MECKLENBURG COUNTY
Park and Recreation Department

MEMORANDUM

RE: Rezoning Petition # 2008-046 (PID # 145-311-01)

Petition #: **2008-046**

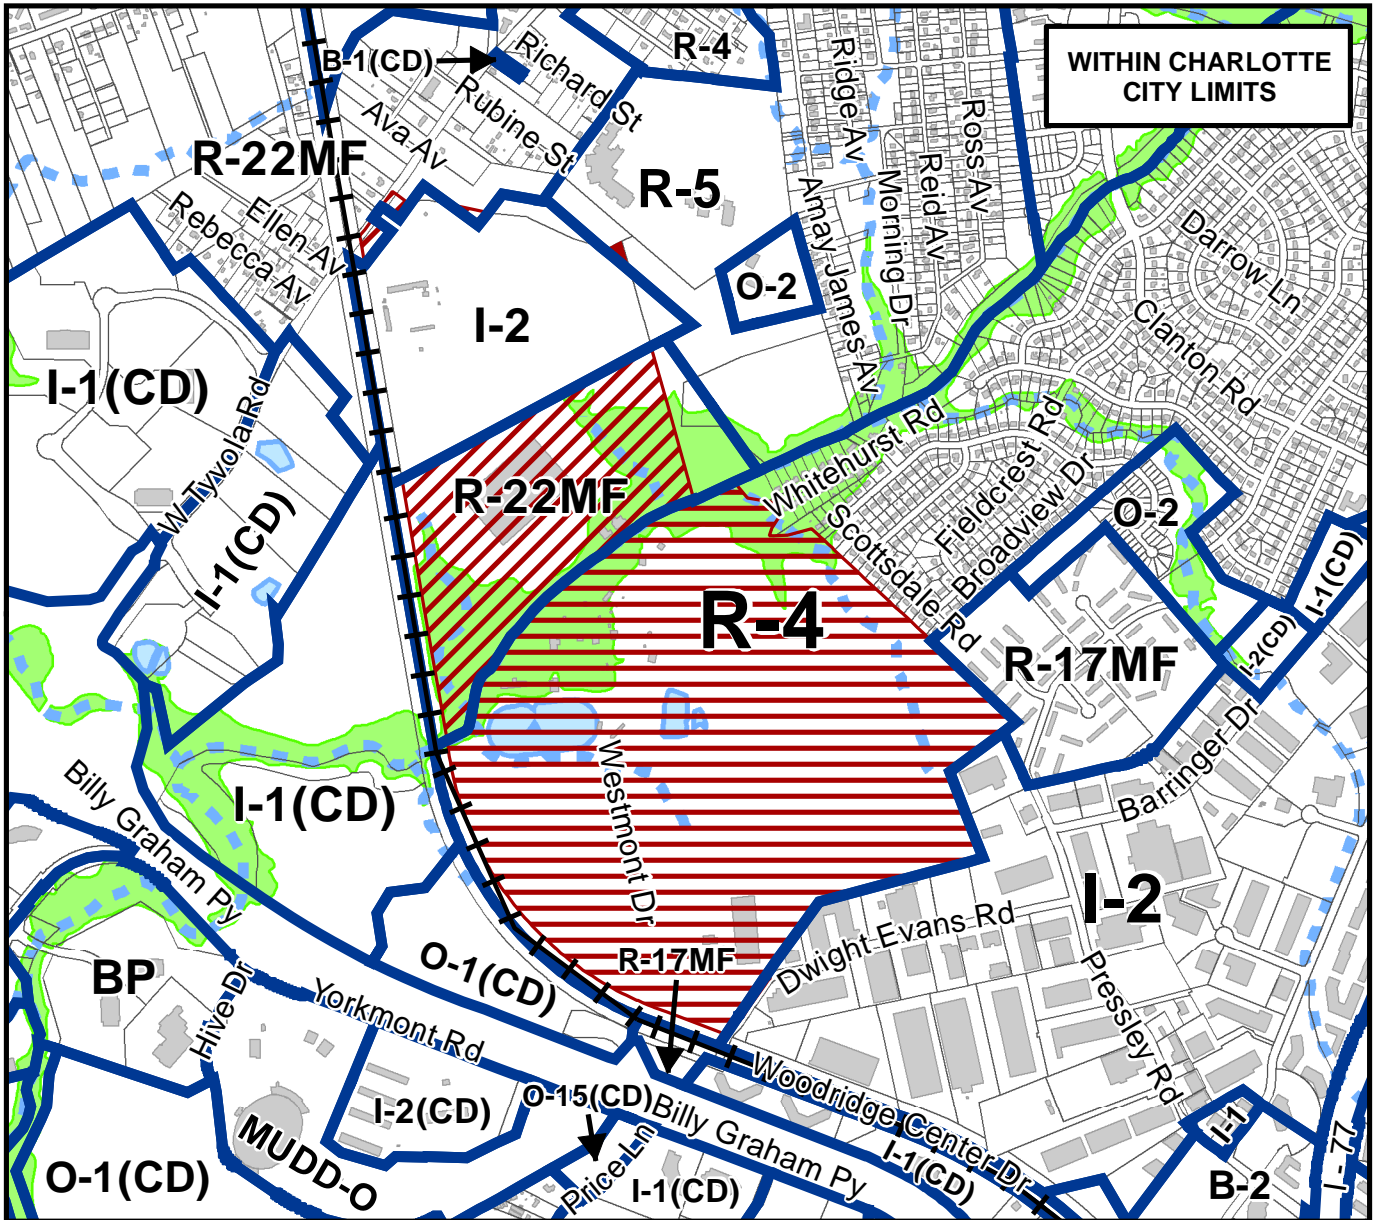
The petitioner's property is located in the Central I Park District and straddles Irwin Creek, a greenway corridor identified in the 1999 Mecklenburg County Greenway Master Plan. Additionally, the petitioner's property is adjacent to Amay James Park. The requested easements below represent a critical greenway linkage between Amay James Park and additional County owned property upstream of the site with future development of greenway downstream at City Park, site of the old Charlotte Coliseum.

MCPR requests a 100' wide easement parallel to Irwin Creek on the northern side of the creek for greenway development. The easement should encompass the existing sewer right-of-way scar to the extent possible while meandering around the plant facilities. Additionally, MCPR requests a 100' wide easement along the eastern property line from Irwin Creek east and south to the property corner nearest Pressley Rd. This easement will allow for a neighborhood greenway connection to Whitehurst Rd. and the multi-family neighborhood near Pressley Rd.
